From: Simon Davis
Sent: 21 July 2026 17:29
To: Planning Scanning
Subject: FW: Planning Consultation on: AL/20/26/PL

I understand from Simon Davis at Arun District Council that you are the drainage officer overseeing the planning application site at West Barns in Norton.

TYPICAL DETAILS OF SOAKAWAY USING
MODULAR UNITS

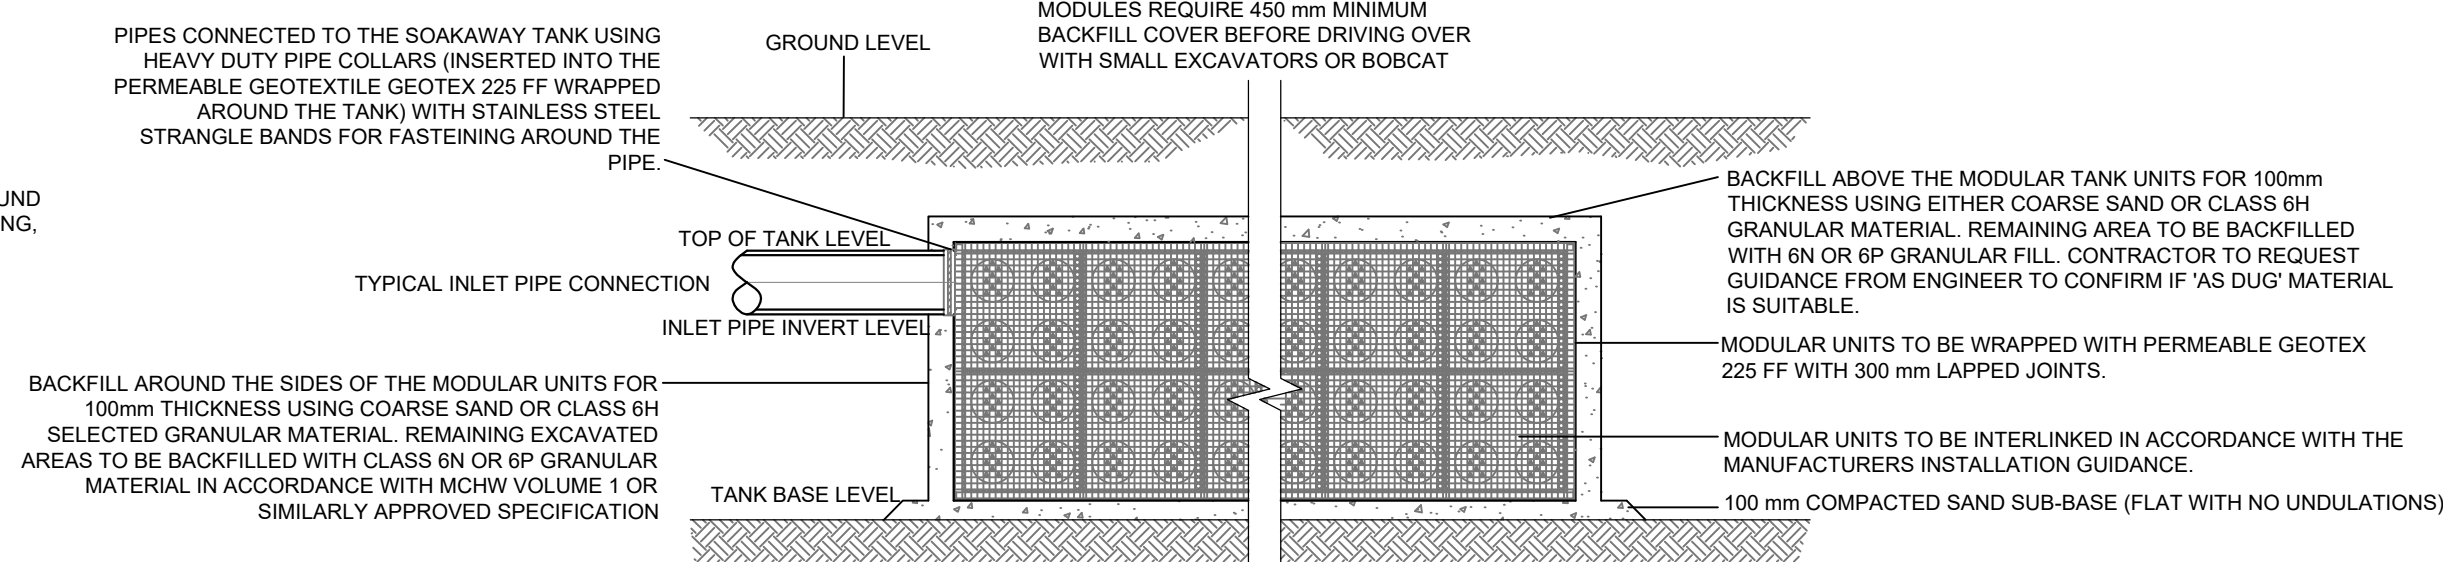
To clarify the comments, the report current notes the testing is to BRE365. The BRE method excludes draining through the base and testing should be carried out in winter or spring. ADC guidance confirm that testing should be carried out in the worst-case conditions (usually winter-Dec to Feb). Following the BRE method the base should be excluded but the FoS applied to the sides would be acceptable to account for the summer testing.

The previously submitted calculation included infiltration at base and sides. There may be an updated set of calculations which was missing from Appendix D which we have not reviewed.

**PROPOSED DRAINAGE LAYOUT**  
SHEET 1 of 2

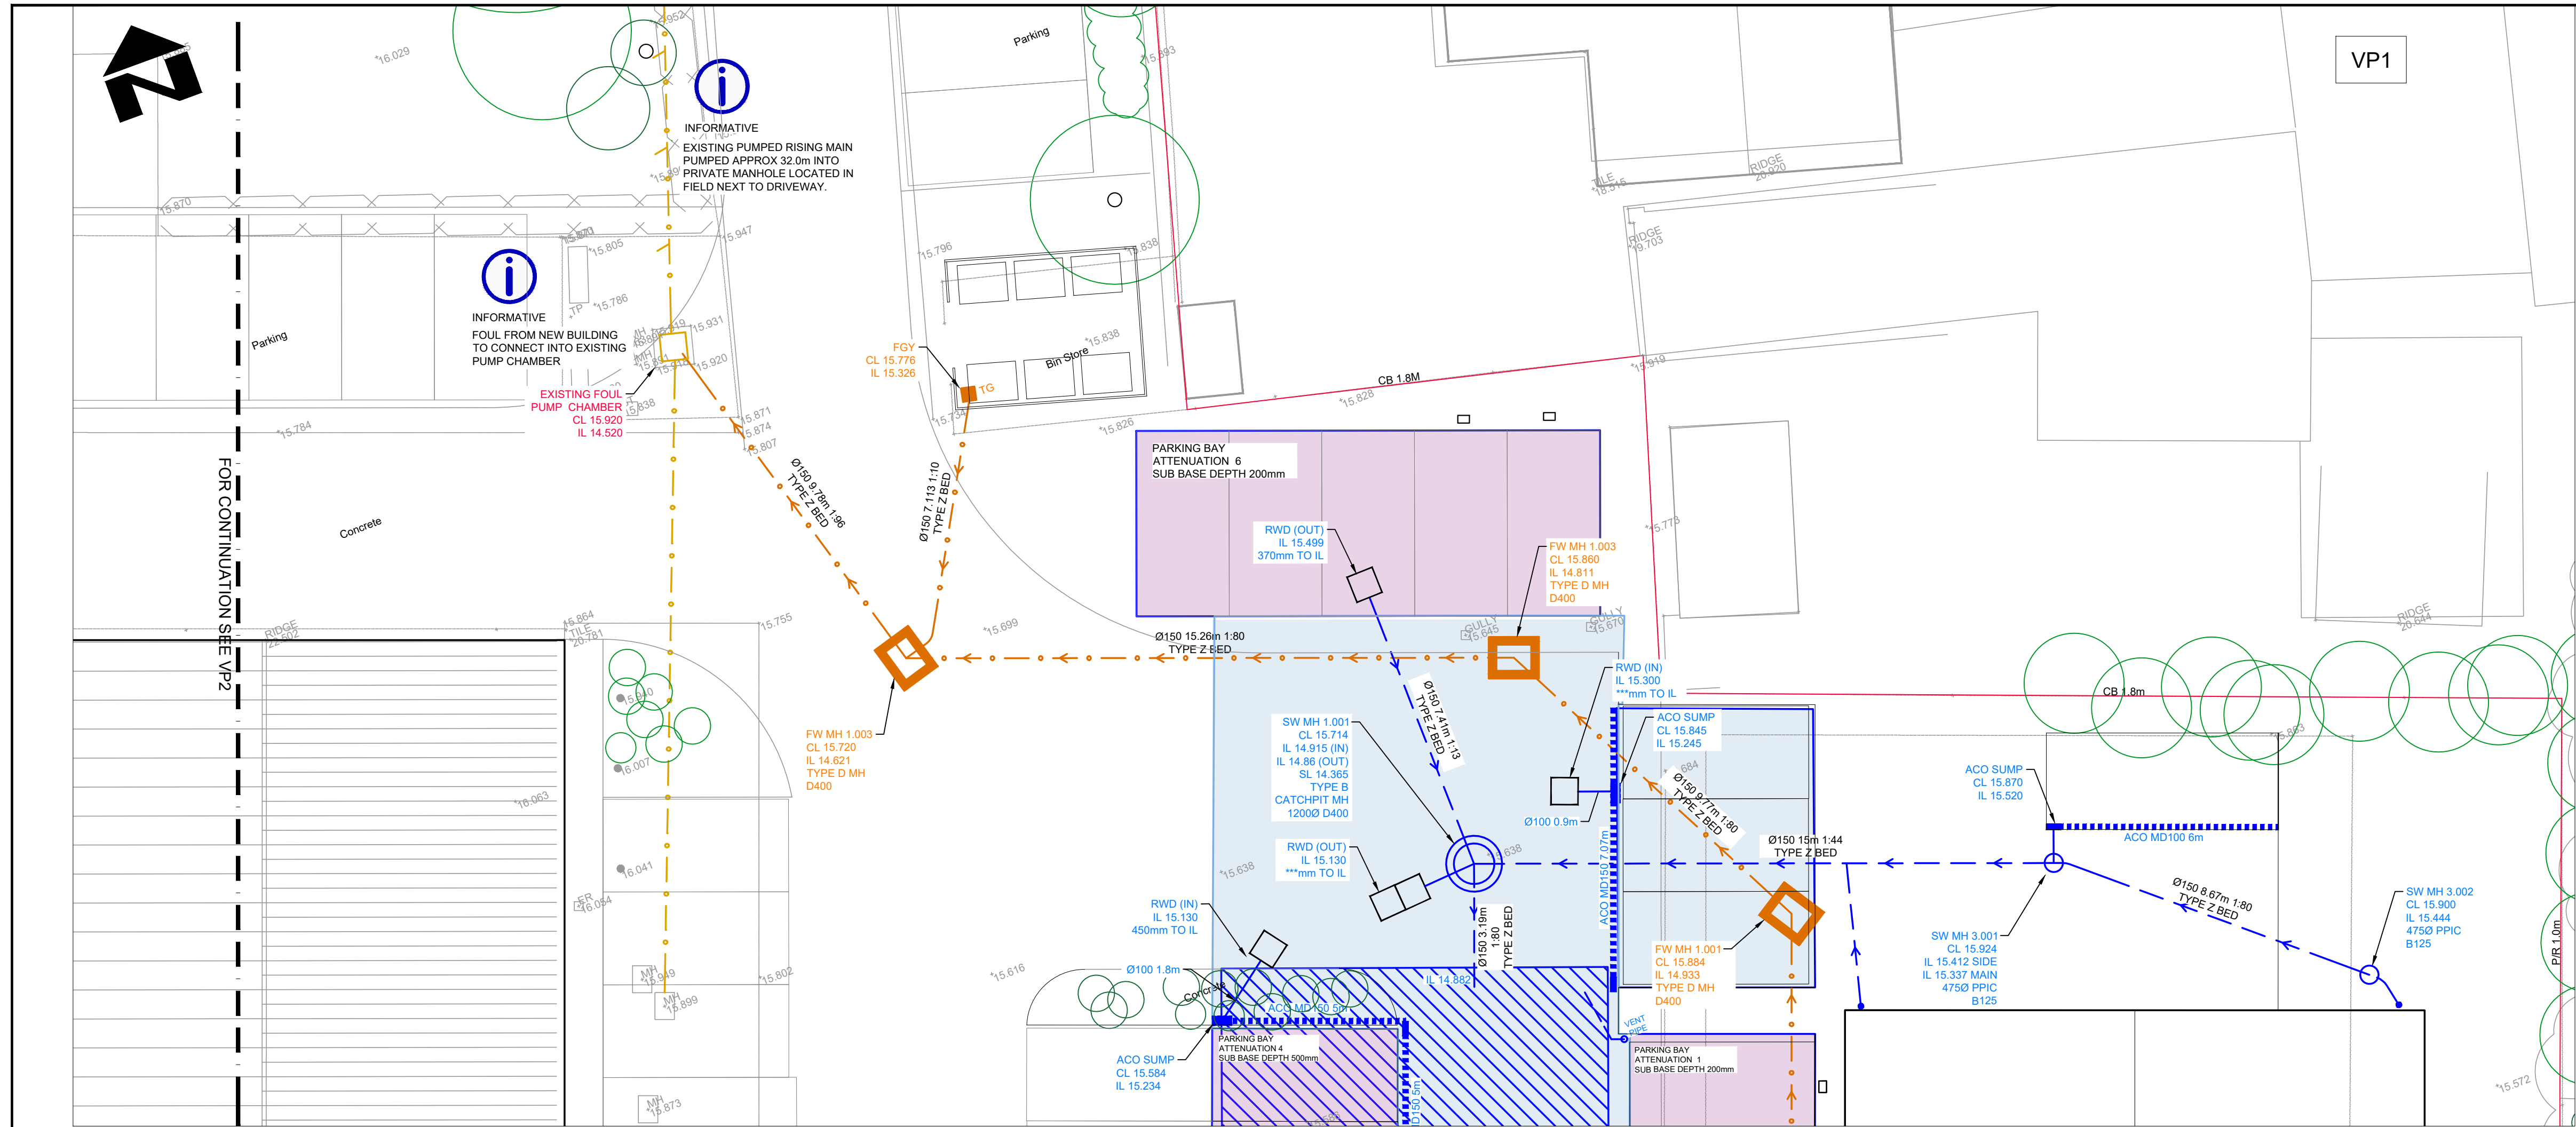
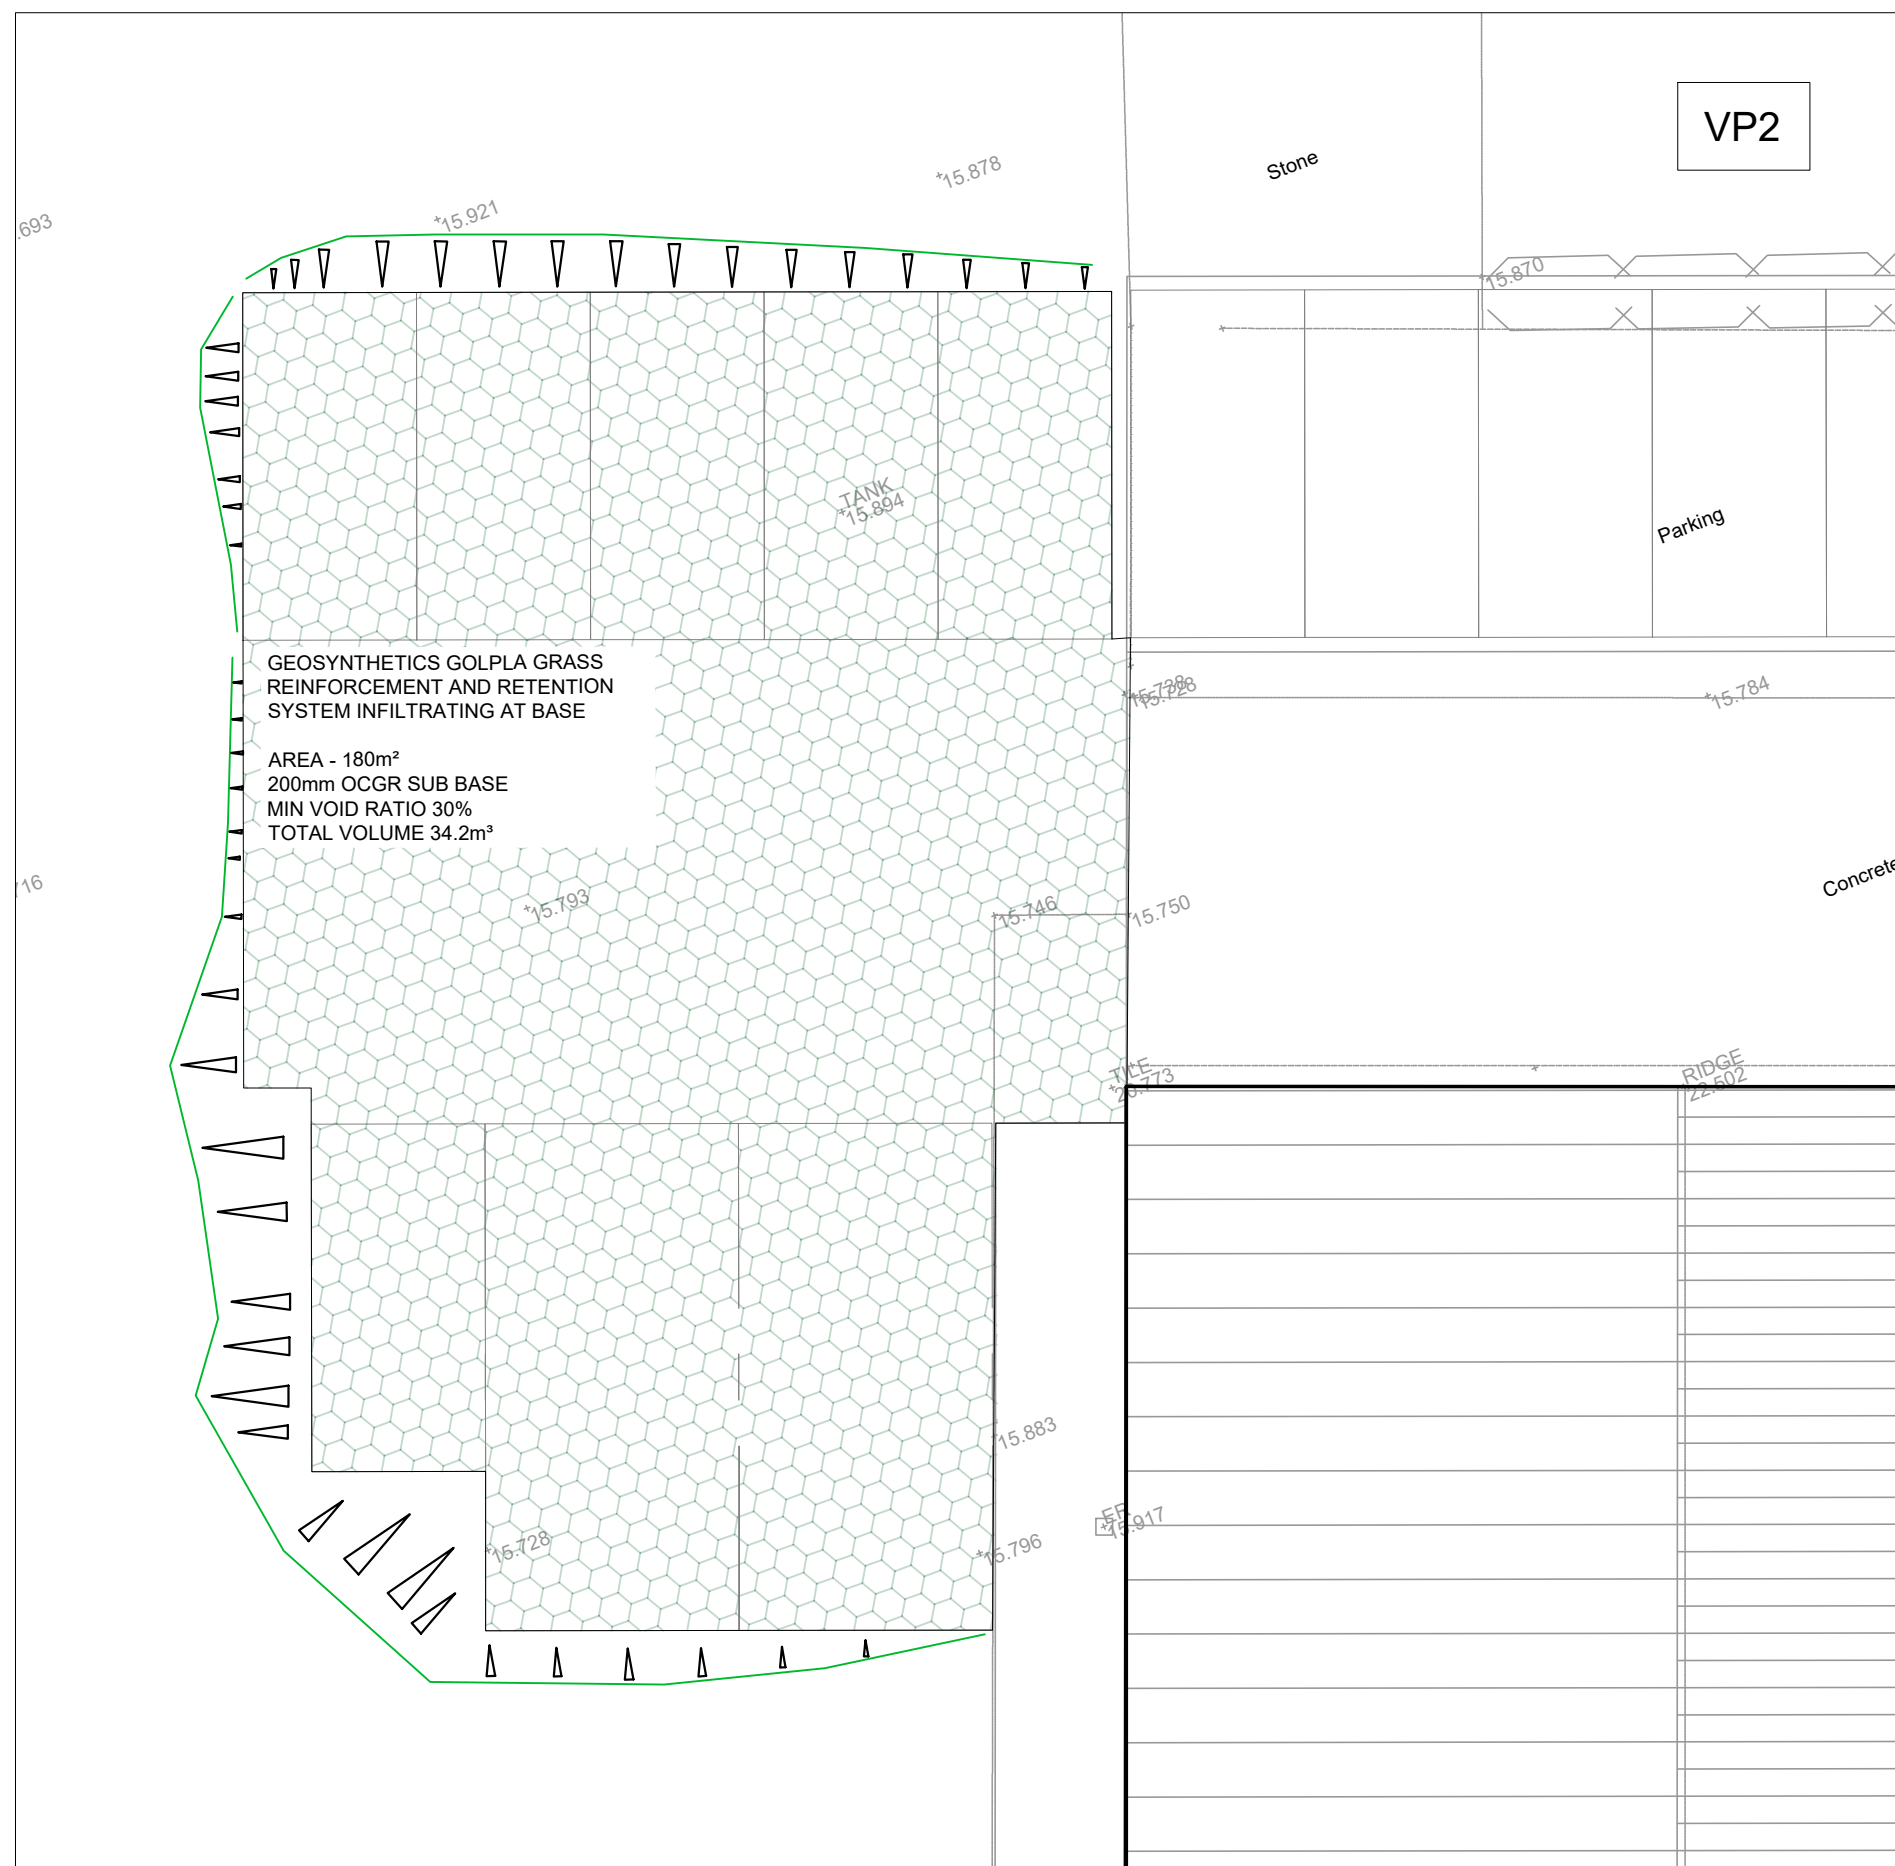
The calculations attached to the email are for another site and not relevant. The criteria listed in the bullet points appears to achieve the required precautionary approach. We will need to review the correct calculations against the revised design drawings. Planning conditions requiring further infiltration testing will still be required.

The additional infiltration testing was undertaken in summer and therefore does not comply with the BRE method or ADC's local requirements, see para 1.6 in the written comments:

'A further round of infiltration testing has been conducted at the correct depth but does not comply with the BRE365 test method which is to undertake testing in Winter or Spring when groundwater levels are high. However, the results show good rates of infiltration in the shallower subsoil. Therefore, the following precautionary approach can be adopted at planning stage; an additional margin of safety should be applied at planning stage to mitigate this aspect and further testing at the depth and location of the soakaway should be provided as part of a submission to discharge conditions.'

In acknowledgement of the positive rates returned and not wishing to unduly delay the application until next winter, we suggested in paragraph 3.3 that an additional factor of safety could be applied on a precautionary basis. The final design will need to incorporate the infiltration rates resulting from further winter testing as discussed above.

The calculations indicate a FoS of 10 was applied. Beneath car parking bay 5 we will provide HydroRock as attenuation, resulting in a void ratio of 94% as shown in the calculations. You will note that all storms up to and including the 1:100 yr+45% climate change storm event are stored below ground, therefore, there will be no flooding.

Following the reduction of 400mm to the base of our soakaway and the 200mm in lieu over and above the 1.0m saturation zone. I think we can safely assume that over the period where wintertime turns into summertime, GWLs would not have risen by 600mm during the dry spell of weather we have had.

- In parking bay no.5 the stone beneath the bays which previously provided a 30% void ratio has been changed to use a hydro rock system that has a 94% void ratio.*
- A factor of safety of 10 has been applied to the soakaway, this is an increase from the previously requested 5. (which exceeds the SuDs guidance which states a FoS of 5 should be used).*
- Calcs still show coefficient at base based on the latest round of infiltration testing.*
